CITY OF ALBUQUERQUE

**Re: Anthea 4th and Granite, Conceptual Grading and Drainage Plan
Engineer's Stamp Date 6-2-14 (J14/D171)**

Based upon the information provided in your submittal received 6-3-14, the above referenced plan cannot be approved for Site Plan for Building Permit until the following comments are addressed:

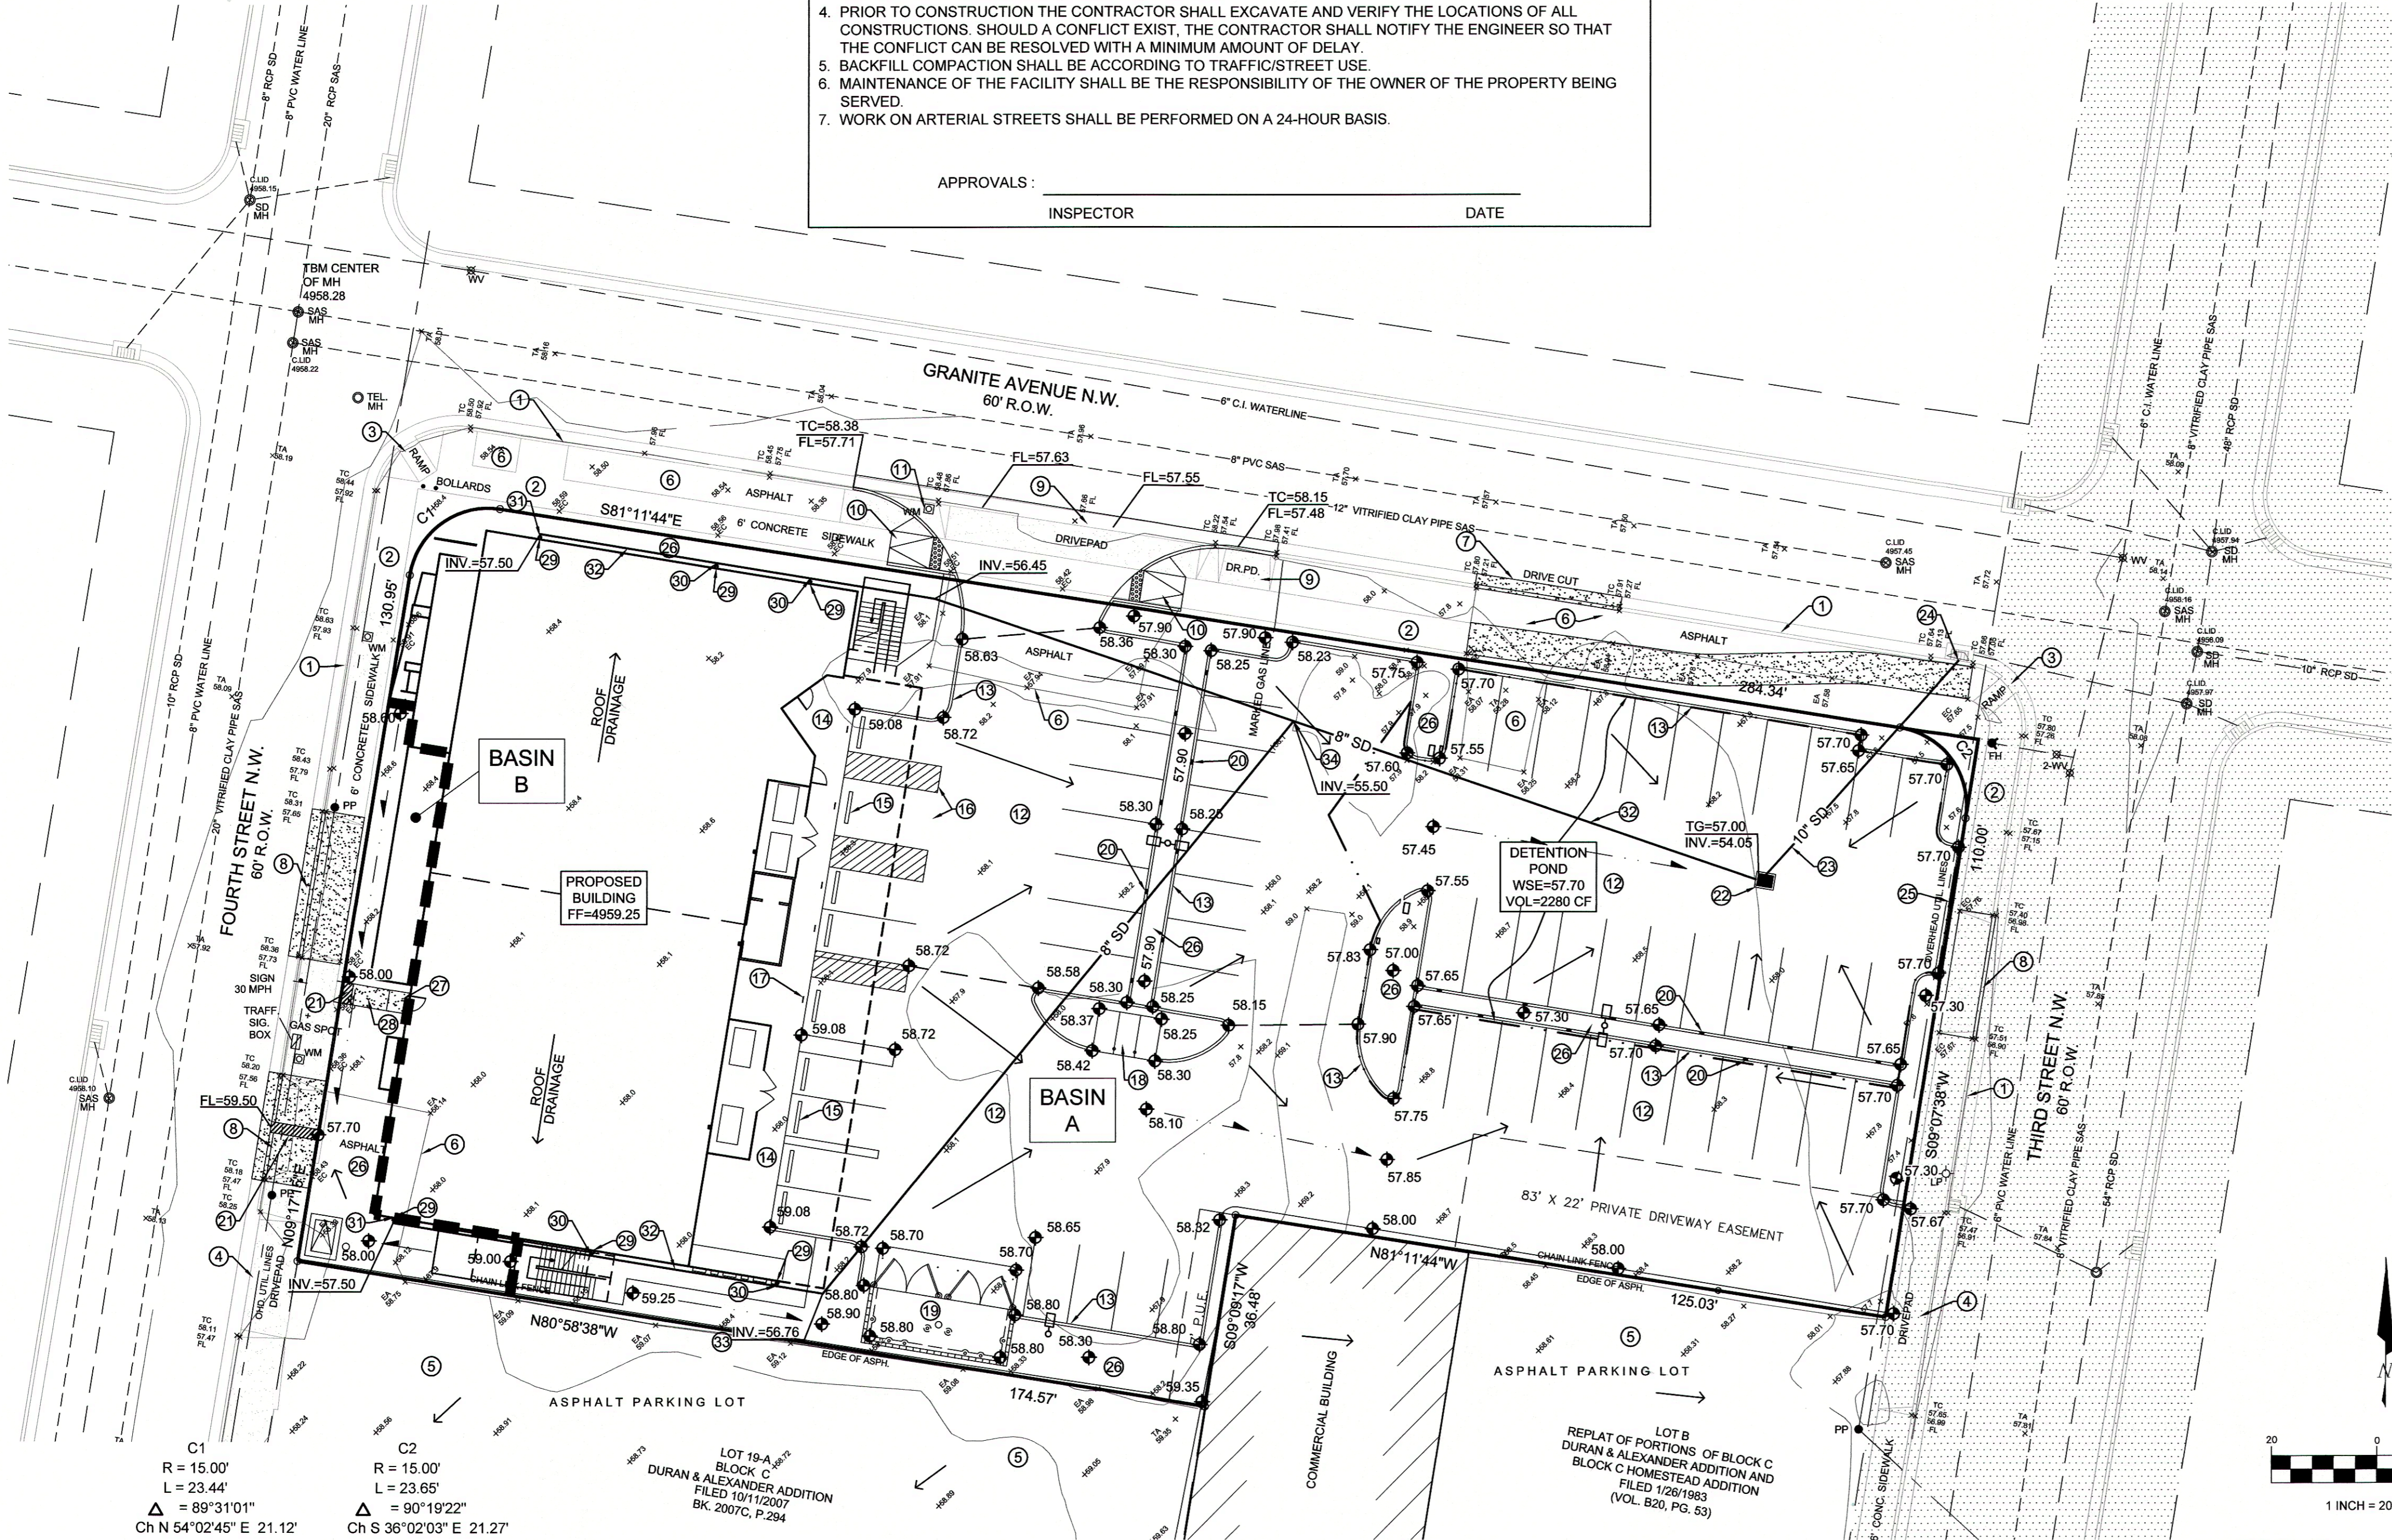
1. The maximum discharge rate for this site is 2.75 cfs/ac. During a predesign in October of 2013 (Hugh Floyd), we figured a pipe into the back of an inlet would be a good way to accomplish this.
2. At DRB, the architect mentioned that the building will drain east. Please show direction of roof flows on the plan.
3. The site plan may change to use the existing drive entrance on Third St. to avoid relocating the inlet. Please revise the plan accordingly.
